# LADACAN response to Rule 17 letter 31 Jan 2024 IP ref 20040757

This is LADACAN’s response to the ExA’s question regarding **Noise insulation delivery programme** copied below from p2 of the Rule 17 letter dated 31 January 2024:

Since the R17 letter was issued, the “Draft Compensation Policies, Measures and Community First” document has been substantially revised and so LADACAN is commenting on REP9-032 rather than REP7-036 in respect of the Noise insulation delivery programme (“the Programme”).

**FIGURE A1.3 - INDICATIVE NOISE INSULATION SCHEME EXTENTS,  
PHASE 2B (2043)**

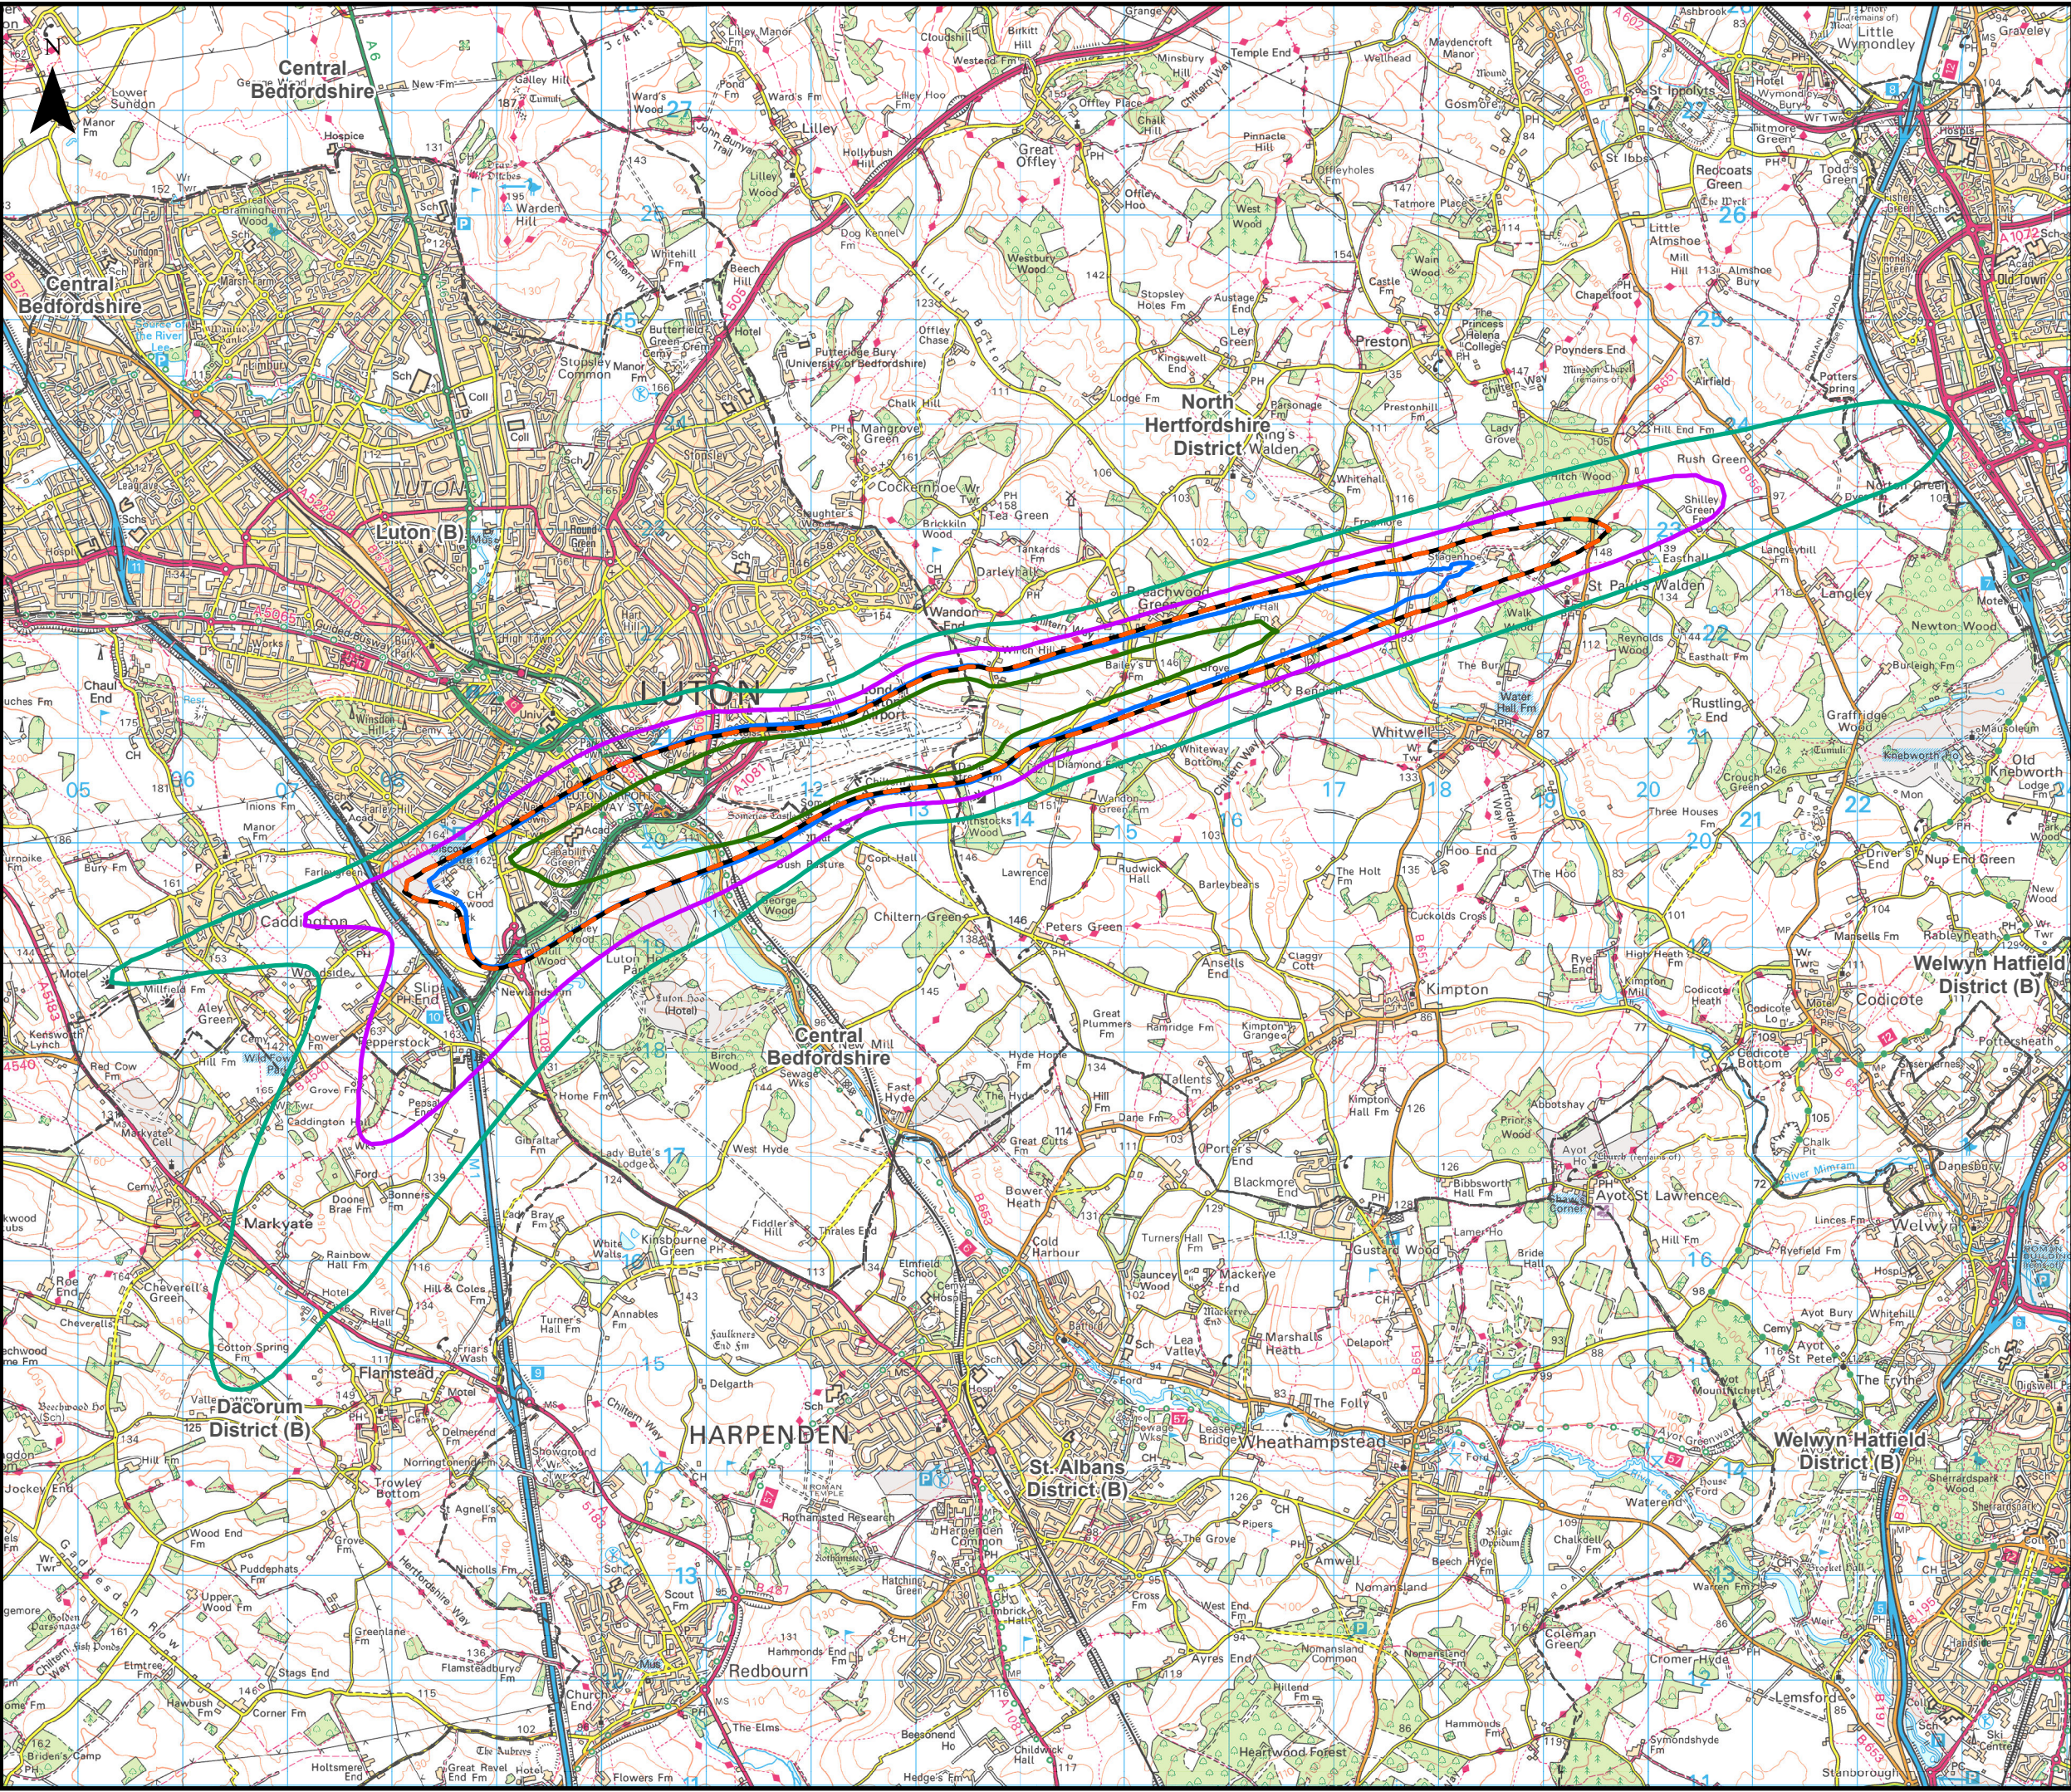
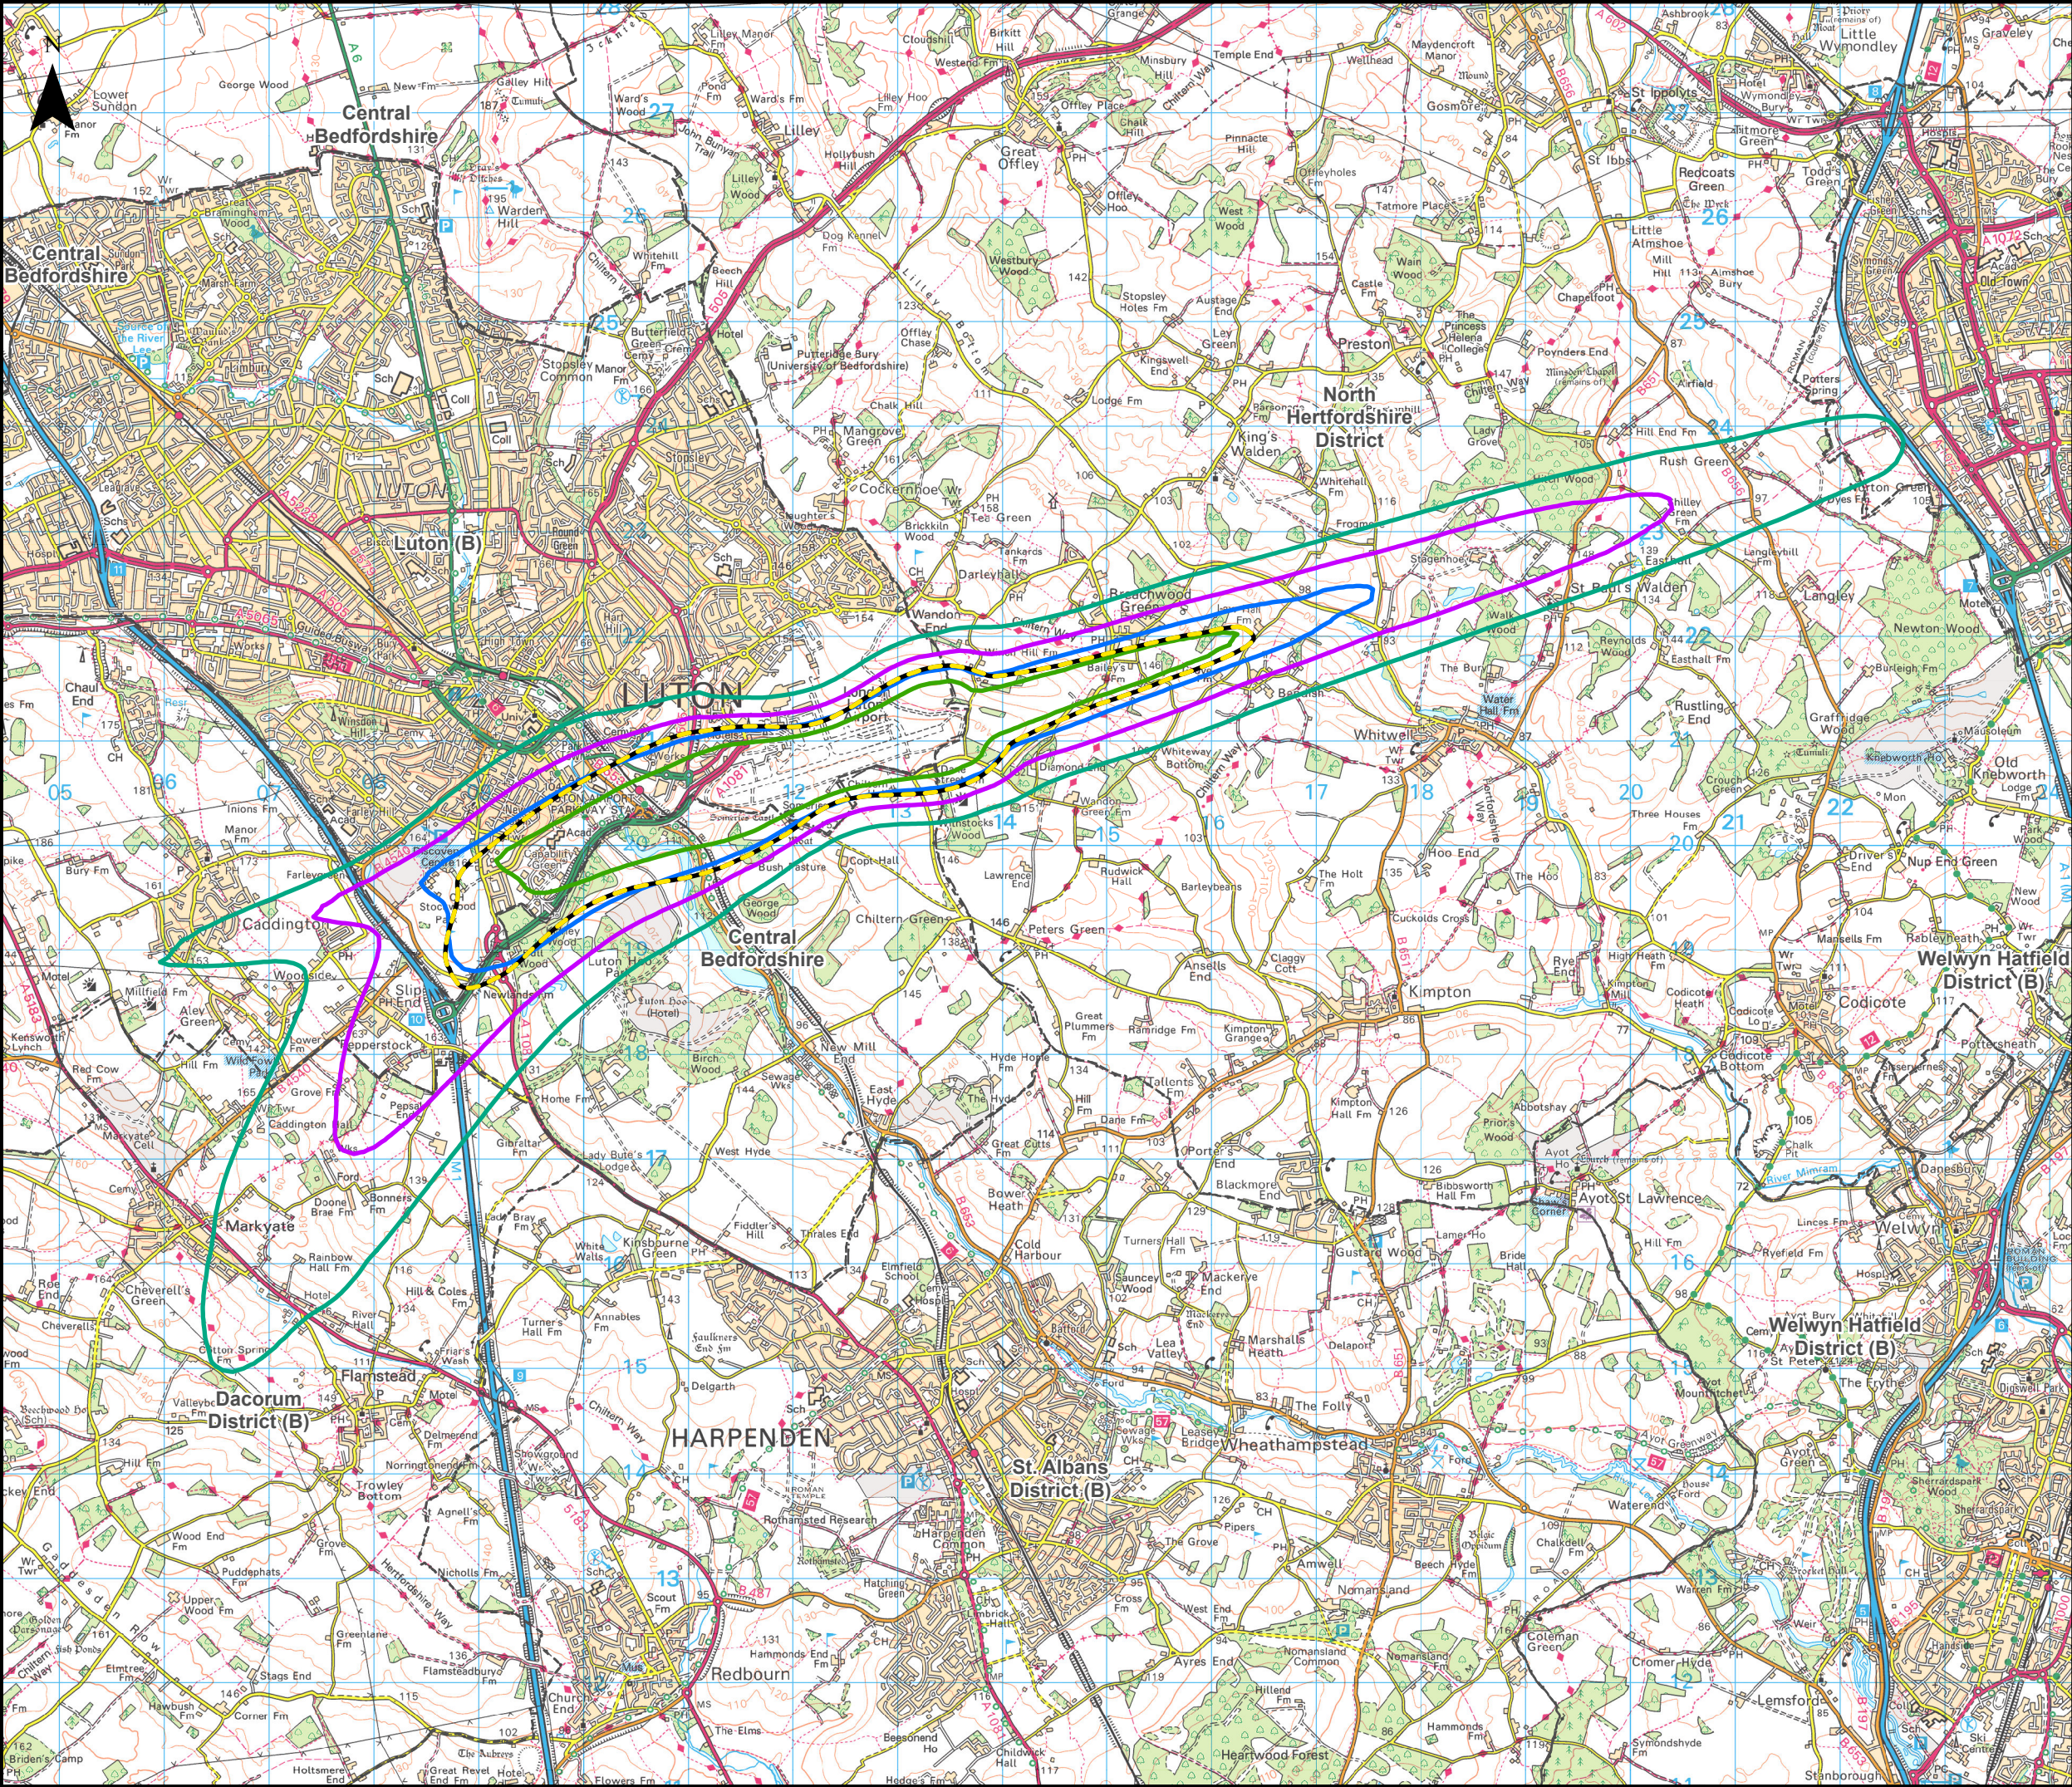
which omits the “outside the 60dB day contour” requirement, as does the wording in the key to the contour maps on PDF pages 36, 38, 40, 44 and 48 which define Scheme 3 as:

*“Scheme 3 - 55dB LAeq,8h Night-Time Contour”*

It is clear from the contour maps which show both the 55 dB LAeq,8h night-time contour and the 60dBLAeq daytime contour that the outlines are nearly identical, with the northern edge of the blue (60dB) line in fact falling outside the dashed blue-orange (55dB) line on its northern edge. Therefore, if the Scheme 3 specification is intended to apply only to properties “inside the 55dB night contour but outside the 60dB day contour”, it would be worthless. This should be corrected.
